From: Liz Annalls [REDACTED]
Sent: 15 December 2020 11:04
To: Planning.Responses <Planning.Responses@arun.gov.uk>
Subject: RE: Planning Consultation on: AB/135/20/OUT

Application No: AB/135/20/OUT
Site Address: Land at Ford Road Arundel
Description of Works: Outline application with some matters reserved (except for access) for the development of 90 dwellings & associated amenity land. This application is a Departure from the Development Plan, affects the setting of listed buildings & affects the character & appearance of the Arundel Conservation Area.

Liz Annalls
Environment Officer
Environmental Protection
Chichester District Council

TITLE
Figure 2: Illustrative Reptile Mitigation Plan

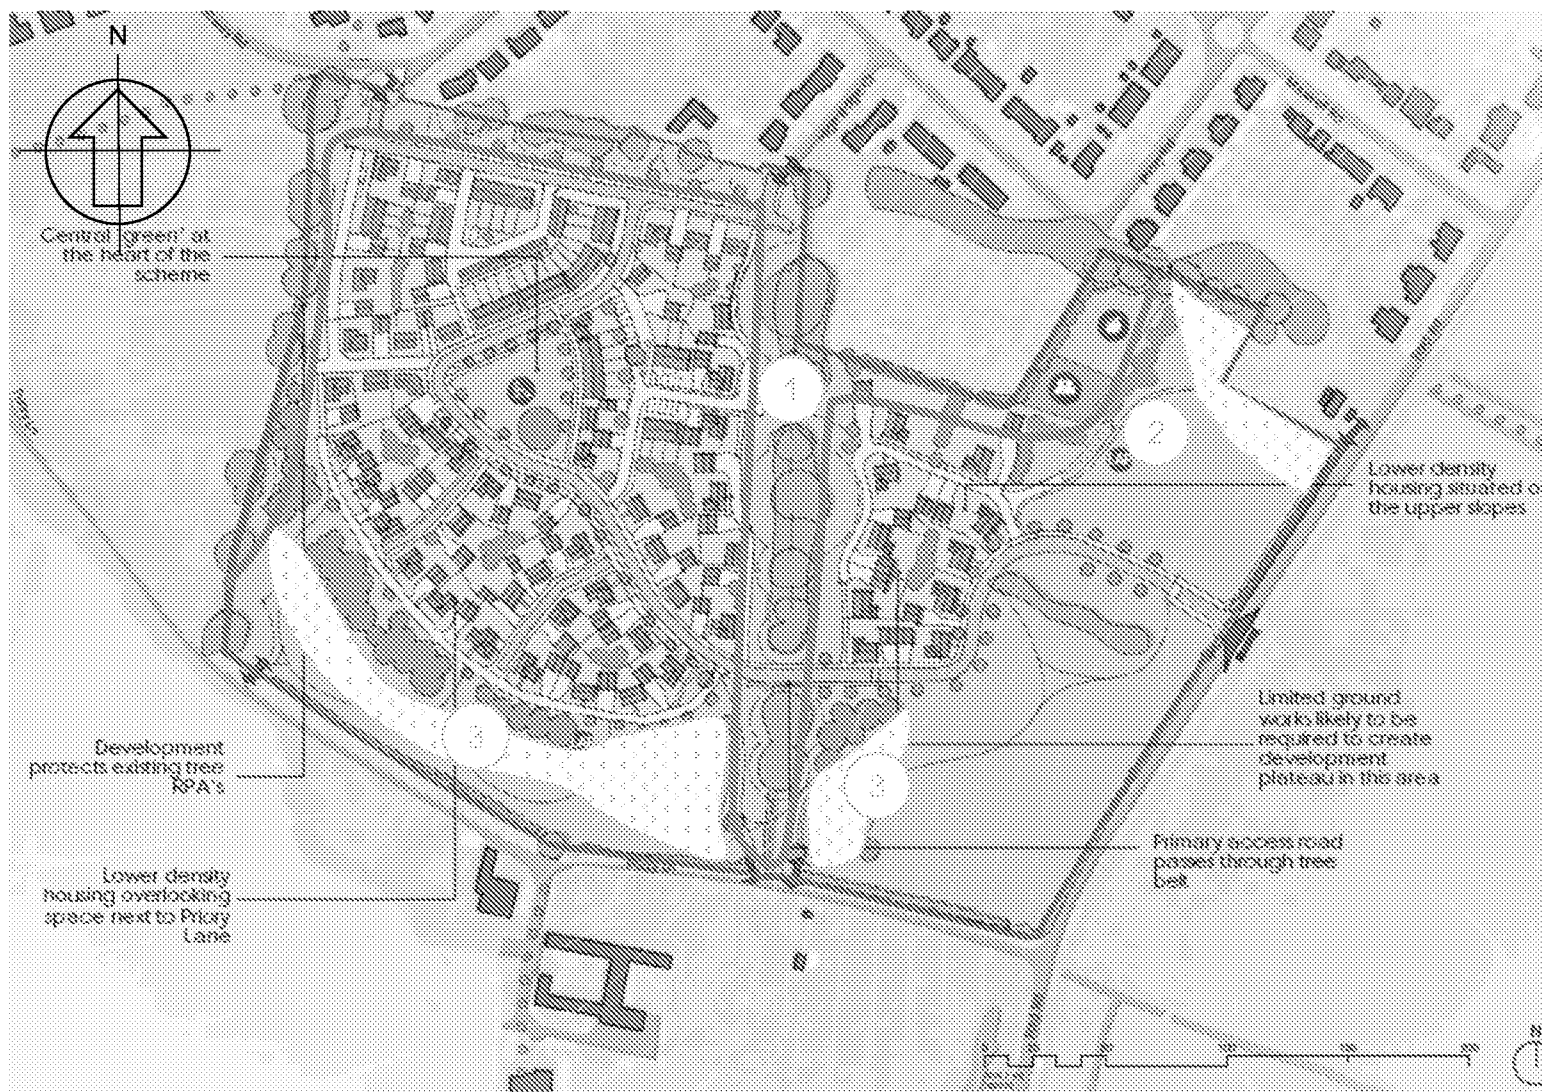
As detailed within the Ecological Assessment Report (Nov 2020) reptiles have been found onsite. Due to this mitigation is required. Unfortunately no mitigation proposals have been included within the assessment, we require that prior to determination a full mitigation strategy is submitted. The mitigation strategy will need to include details of reptile fencing, translocation methods, the translocation site / enhancements and the timings of the works.

We are pleased to see that areas of grassland and a new wetland area will be recreated onsite which will benefit GCN. We require that a precautionary approach is taken for GCN and further details of this should be included within the reptile mitigation strategy discussed above.
